A46 Newark Bypass

Statement of Common Ground with Think Again A46 Winthorpe Action Group

**Statement Of Common Ground with
Think Again A46 Winthorpe Action Group - TA**

Regulation Number:	8(1)(e)
Planning Inspectorate Scheme Reference	TR010065
Application Document Reference	7.31
Author:	A46 Newark Bypass Project Team, National Highways

DRAWING NUMBER HE551478	ORIGINATOR SKAG	VOLUME HGN	PROJECT REF NO. HE551478
CONWI_CONW	DR	LE	00003
LOCATION	TYPE	ROLE	NUMBER
			C01

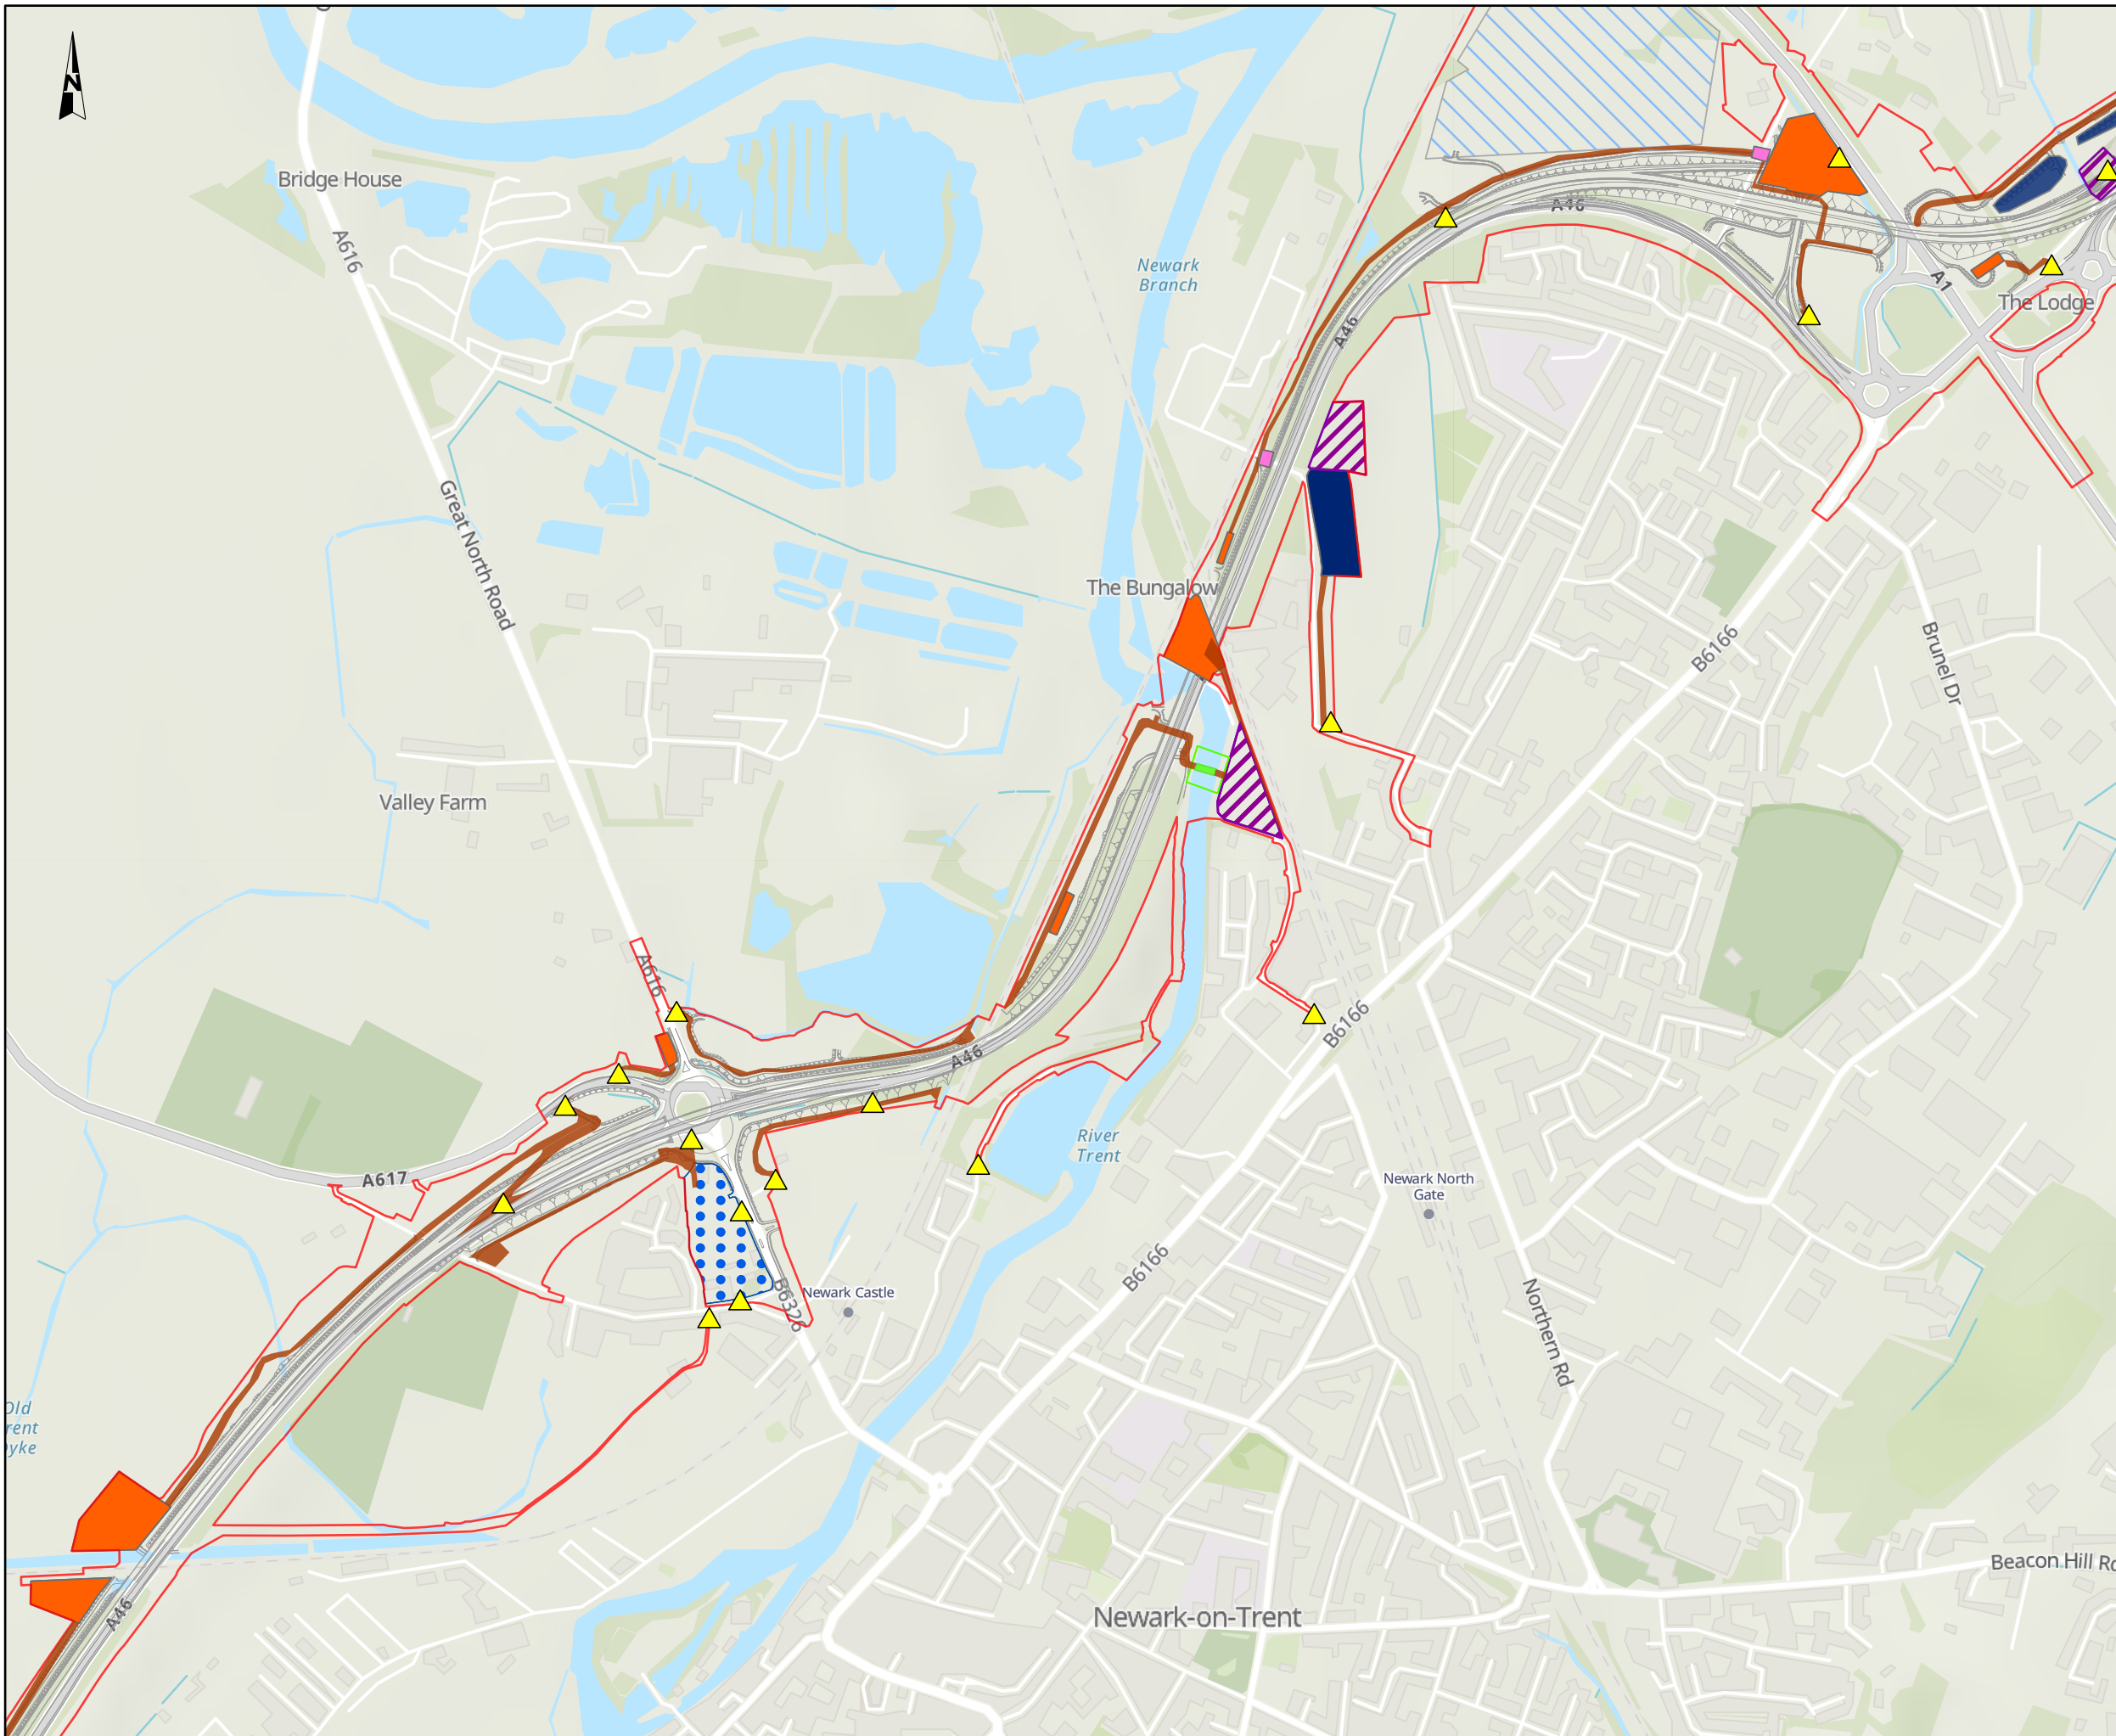
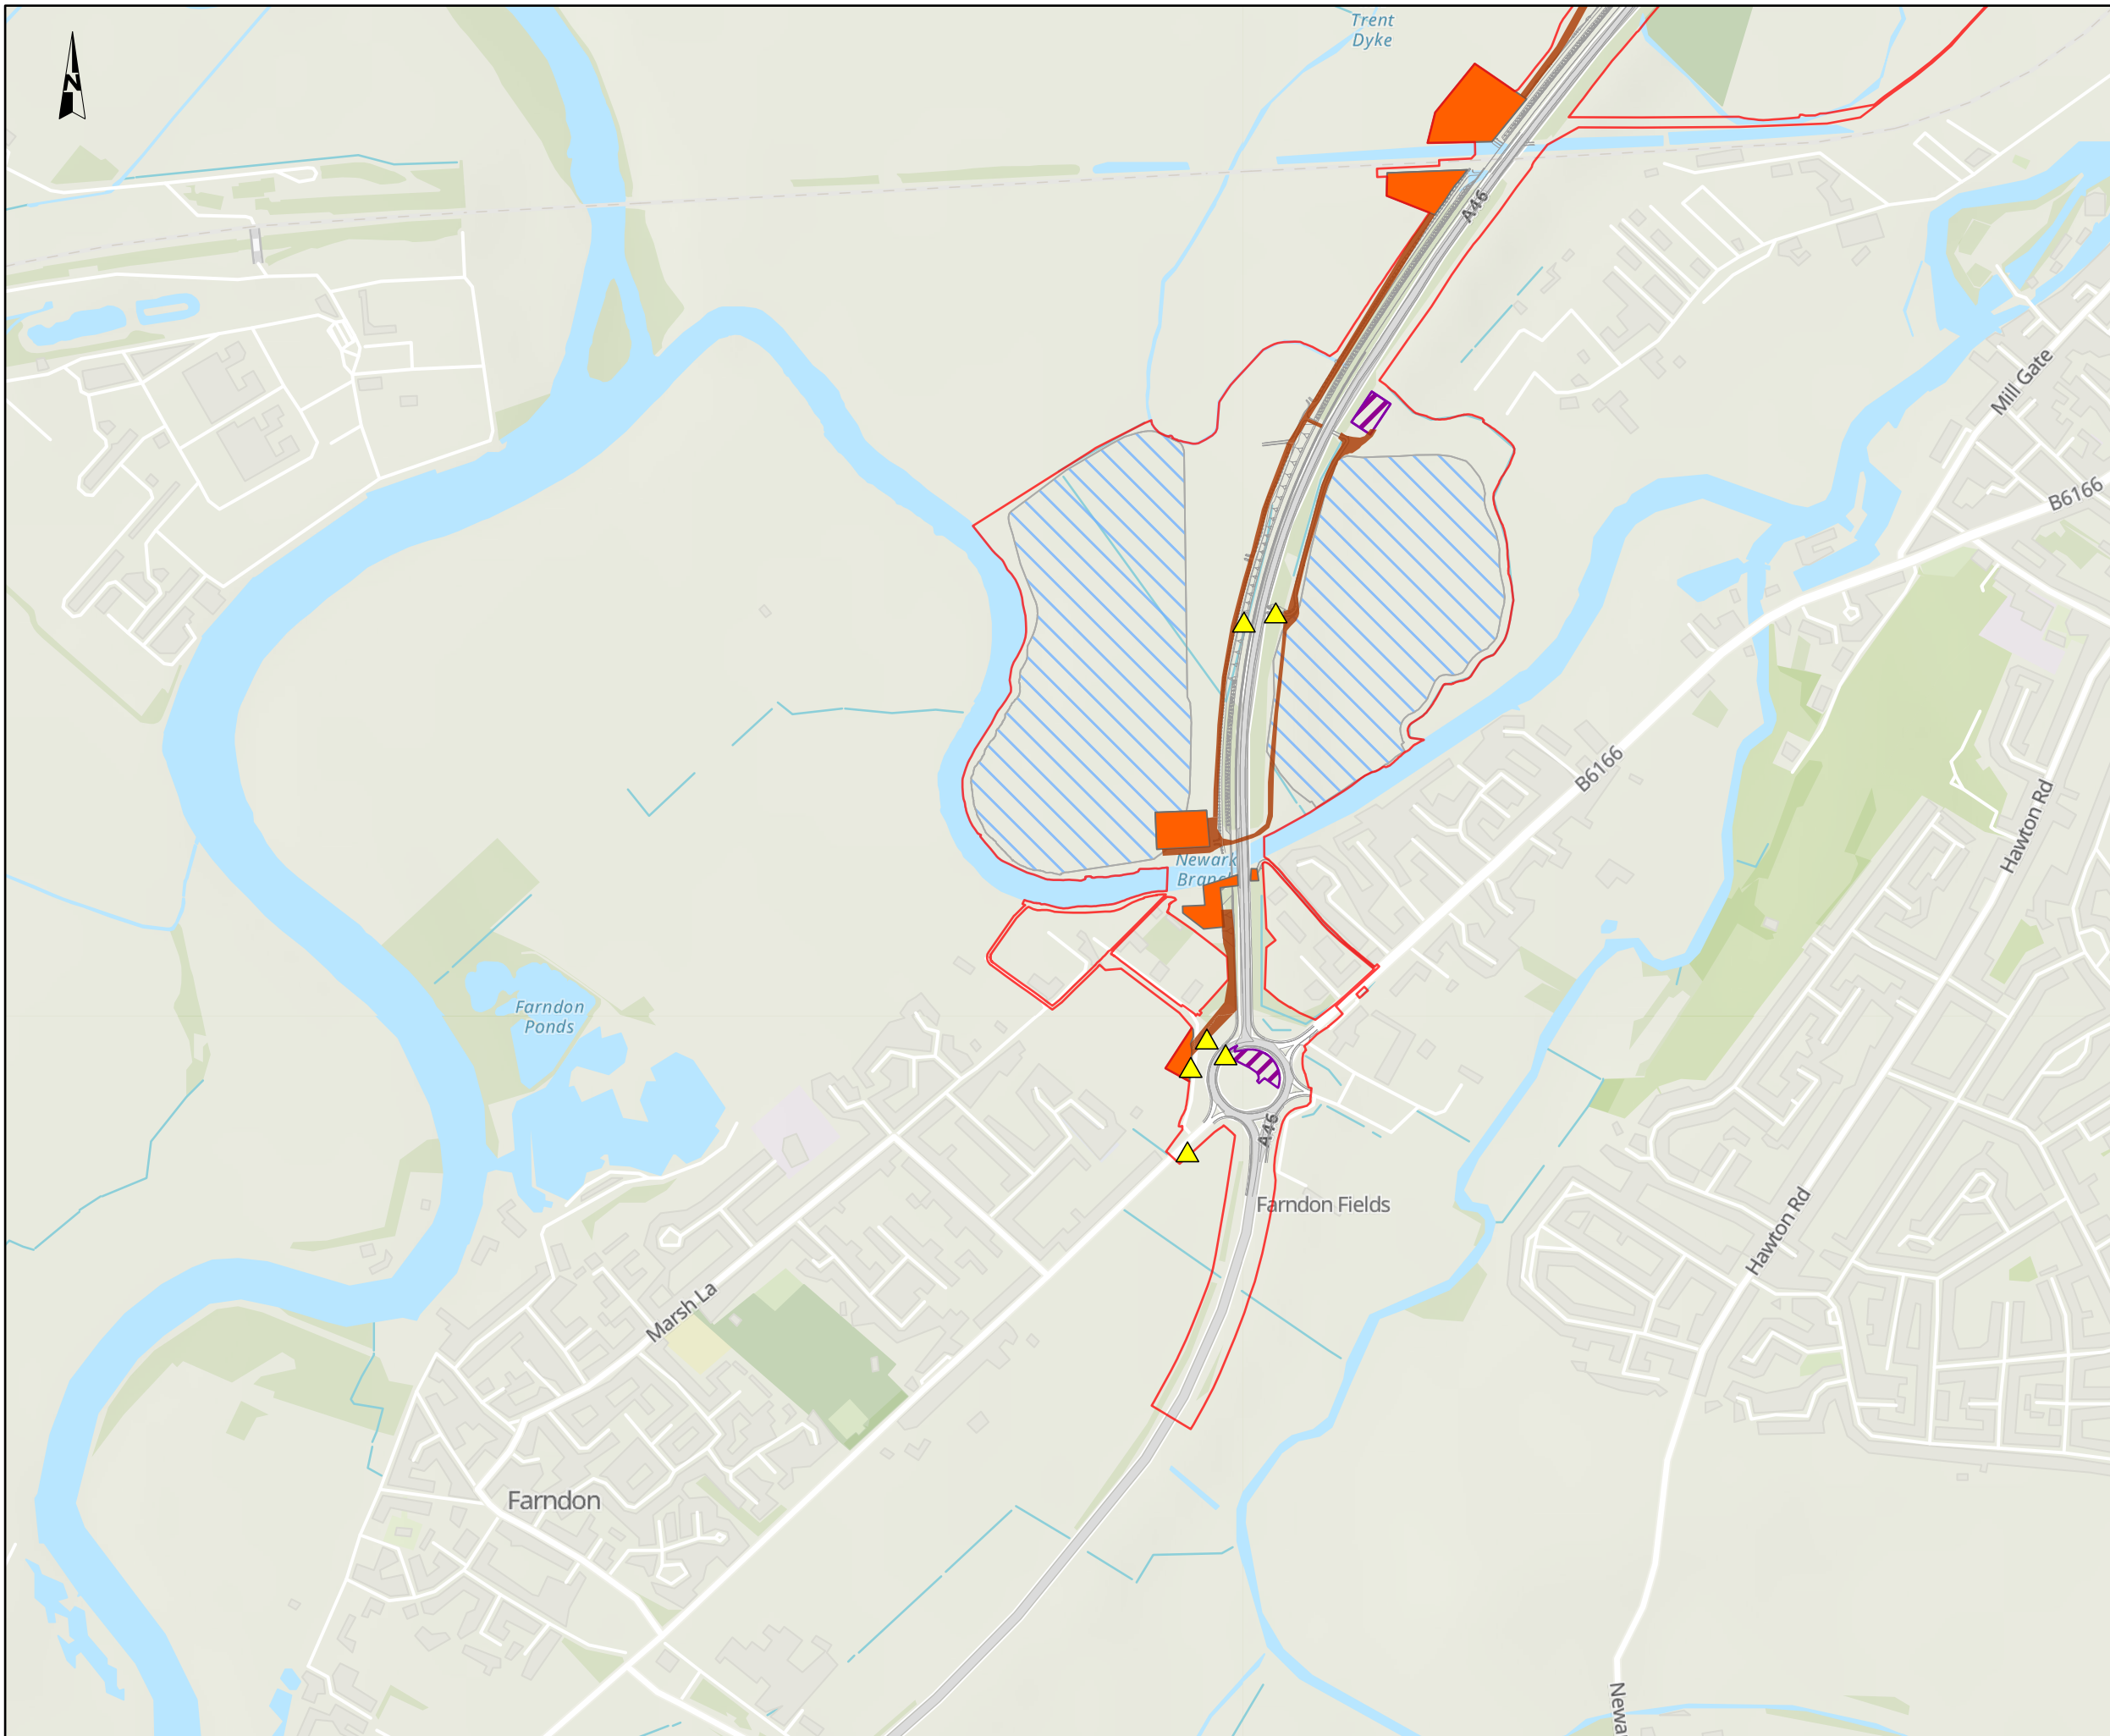
20.	Construction Compounds	<p>Figure 2.4 Locations of Temporary Works Areas Required During Construction of the Environmental Statement Figures [AS-027]</p> <p>Table 2-6 in Chapter 2 The Scheme of the Environmental Statement [APP-046]</p>	What construction compounds and works access facilities will be located in the Winthorpe area?	The location of the construction compounds and works access areas within the Winthorpe area are detailed on Figure 2.4 Locations of Temporary Works Areas Required During Construction of the Environmental Statement Figures [AS-027] and in Table 2-6 in Chapter 2 The Scheme of the Environmental Statement [APP-046].	Agreed	24/09/2024
